Further (amended) WSCC Highways Comments

TO:	<u>Arun</u> District Council <u>FAO:</u> Simon Davis
FROM:	<u>WSCC</u> - Highways Authority: Tim Townsend
DATE:	21 July 2020
LOCATION:	Wings Nursery <u>Lidsey</u> Road <u>Woodgate</u> <u>PO20 3SU</u>
SUBJECT:	AL/46/20/PL Demolition of Wings House & the erection of 81 No. <u>replacement</u> dwellings (80 net new dwellings), access arrangements, sustainable drainage measures, public open space, landscaping & all other associated works. This application is a Departure from the Development Plan. FURTHER RESPONSE ISSUED IN-LIGHT OF NEW LPA CIL REQUIREMENTS
DATE OF SITE VISIT:	n/a (visited as part of the assessment undertaken for previous proposals AL/117/17/OUT and AL/32/19/OUT).
RECOMMENDATION:	More Information Required
S106 CONTRIBUTION TOTAL:	TBC

This is the second WSCC County Highway Authority (CHA) response to the above planning application for demolition of Wings House & the erection of 81 No. replacement dwellings (80 net new dwellings), access arrangements, sustainable drainage measures, public open space, landscaping & all other associated works. The LPA reports that the application is a departure from the Development Plan.

9 LAYOUT - SITE PLAN

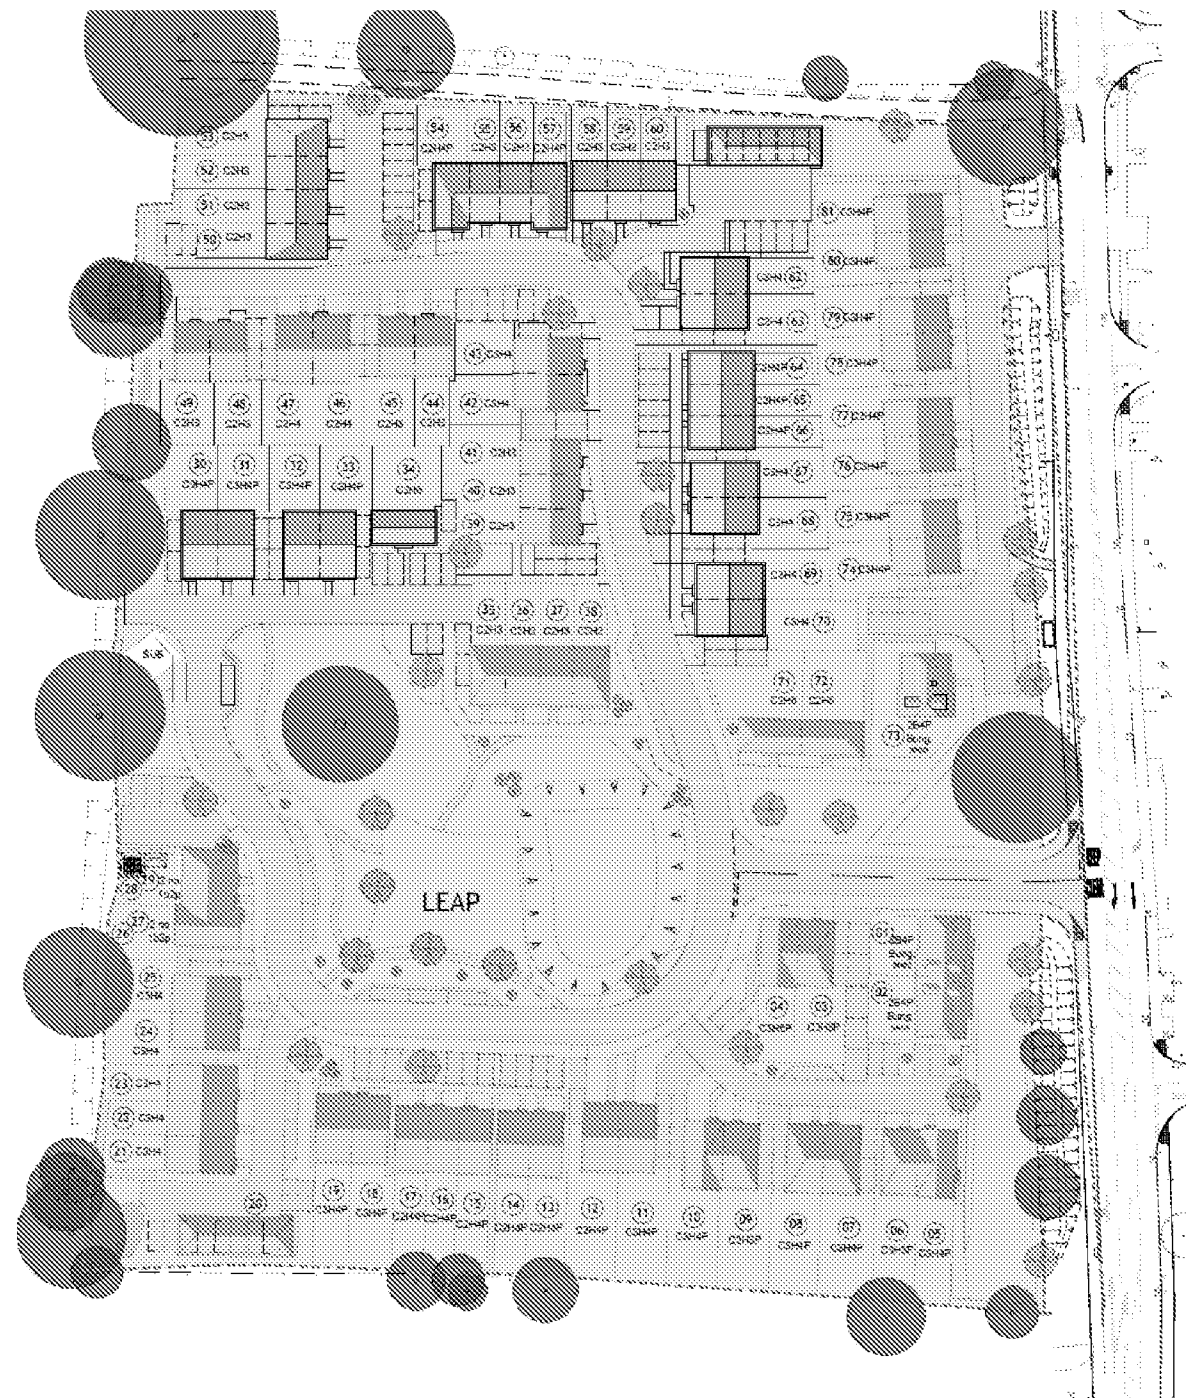
- There appears to be lack of convenient visitor parking throughout the layout – particularly by plots 30-34, 43-60 and 70-81 and on the first section of the main estate road between A29 running past plots 01-04.
- Turning for vehicles – particularly service vehicles – is lacking in certain areas of the site. This could make it difficult to access dwellings for purposes of refuse

collection and, more importantly, fire appliance access. Key areas of concern are adjacent to plots 05-08. However, access roadways adjacent to plots 30-33 and outside plots 46-49 and 50-53 should be not less than 4.8m wide to prevent blockage of on-street car parking takes place, possibly causing an obstruction for a fire appliance. Finally on this point, the turning head adjacent to plots 73 and 74 appears to be too small to allow a refuse vehicle to be able to turn around.

- Parts of the layout give a 'mixed message' with regard to user priority etc. One example is outside plots 43 and 63 where footways tend to terminate and are not continuous, suggesting that the road serving plots 43-60 is to be a shared-surface (so no footways). This should be re-visited and re-designed to follow Manual for Streets (MfS) principles with clear delineation of traditional roads and footways and where these change to shared-surfaces.

- A large number of the parking spaces appear to be narrow with a number in confined spaces. This will make them difficult to use and un-attractive to users, resulting in parking on-street. As such, all parking design should be re-visited with regard to sizing/dimensions. Single spaces with no obstructions either-side – should measure 2.4m wide and 5.5m long. Where driveways are 'shared' (so household spaces next to one-another), driveways should be 6.0m wide. If spaces are to be bounded by obstructions (e.g. walls, fences etc.), single spaces should be widened to at least 3.5 wide and dual spaces to 7.0m wide. Where garages are to be used, these should have internal measurements of 6m x 3m.

- The provision of a foot/cycle-path link in the top north-eastern corner of the site to provide a link for properties in the northern part of the site to A29 would be beneficial and reduce travel time to local facilities for those travelling on-foot.

- The provision of a foot/cycle link from the end of the driveway adjacent to plots 1, 2 and 5 to the primary access road would assist with ped and cycle movement from this part of the site.

- Tactile paving will be required within the layout at junctions (not currently shown).

Drawing No.	Rev.
2019-6115-002	F

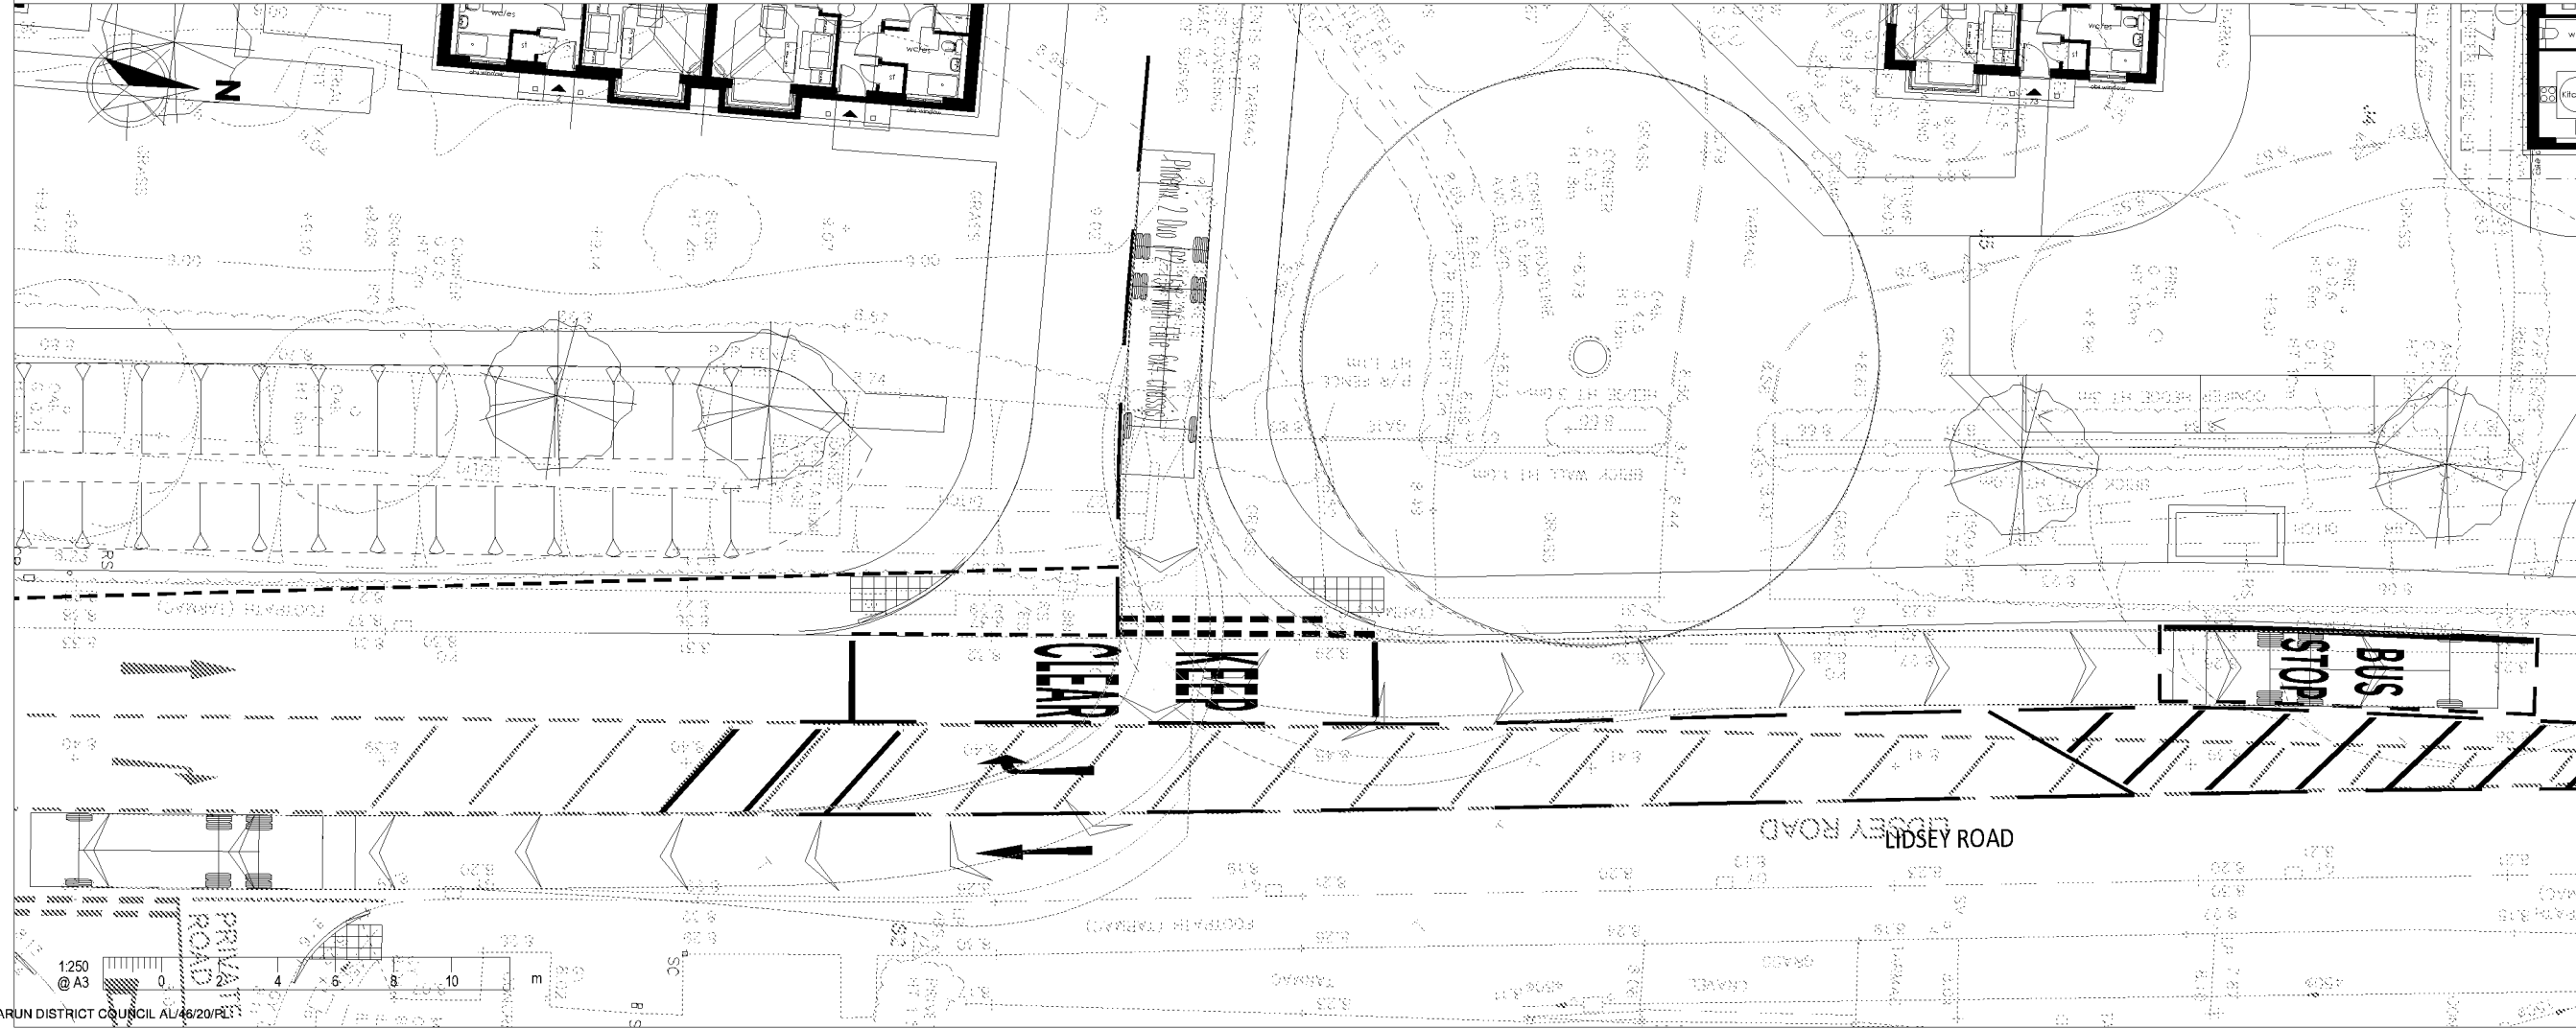
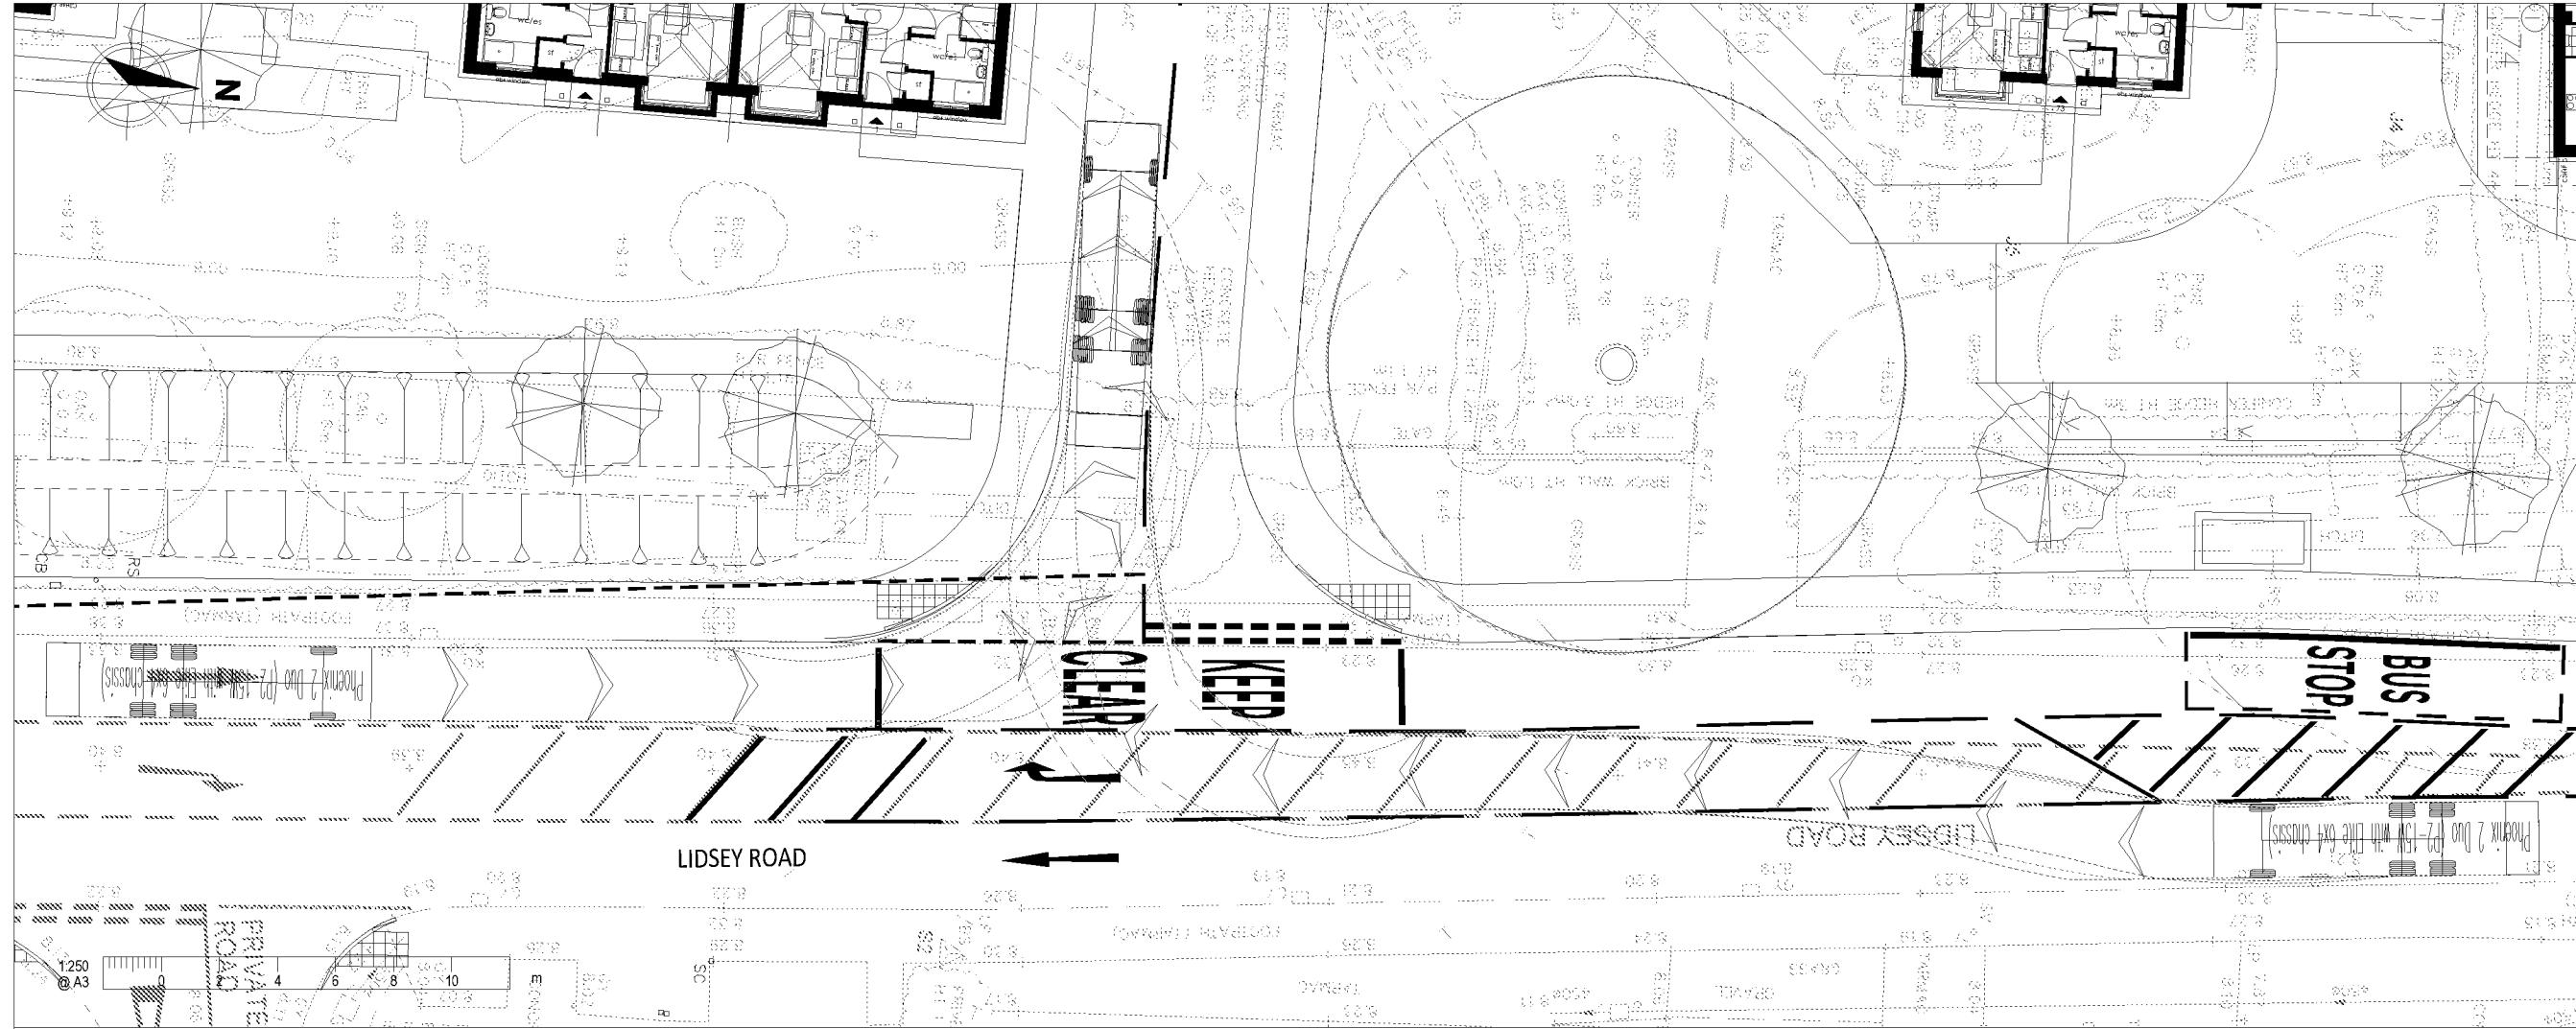
refuse vehicle is large enough (a tracking diagram for a fire appliance has already been provided). A plan and tracking information to demonstrate the latter is required.

- A tracking diagram should be provided showing a refuse vehicle turning in the turning area in the private 'secondary driveway' adjacent to plots 73 and 74.
- The northern end of the private driveway (secondary access) should be extended slightly further northwards to provide improved turning for vehicles emerging from plot 81. At present, the turning area in this location is not well defined on the drawings and suggests that it would be too restrictive.
- A tracking diagram for a selection of vehicles should be provided showing their path around the proposed relocated north-bound bus stop marking on the A29. As shown, there appears to be a potential conflict point where vehicles attempting to overtake a stationary bus would enter part of the right hand turning lane which could result in collisions. As a result, the bus cage and bus stop might need moving.
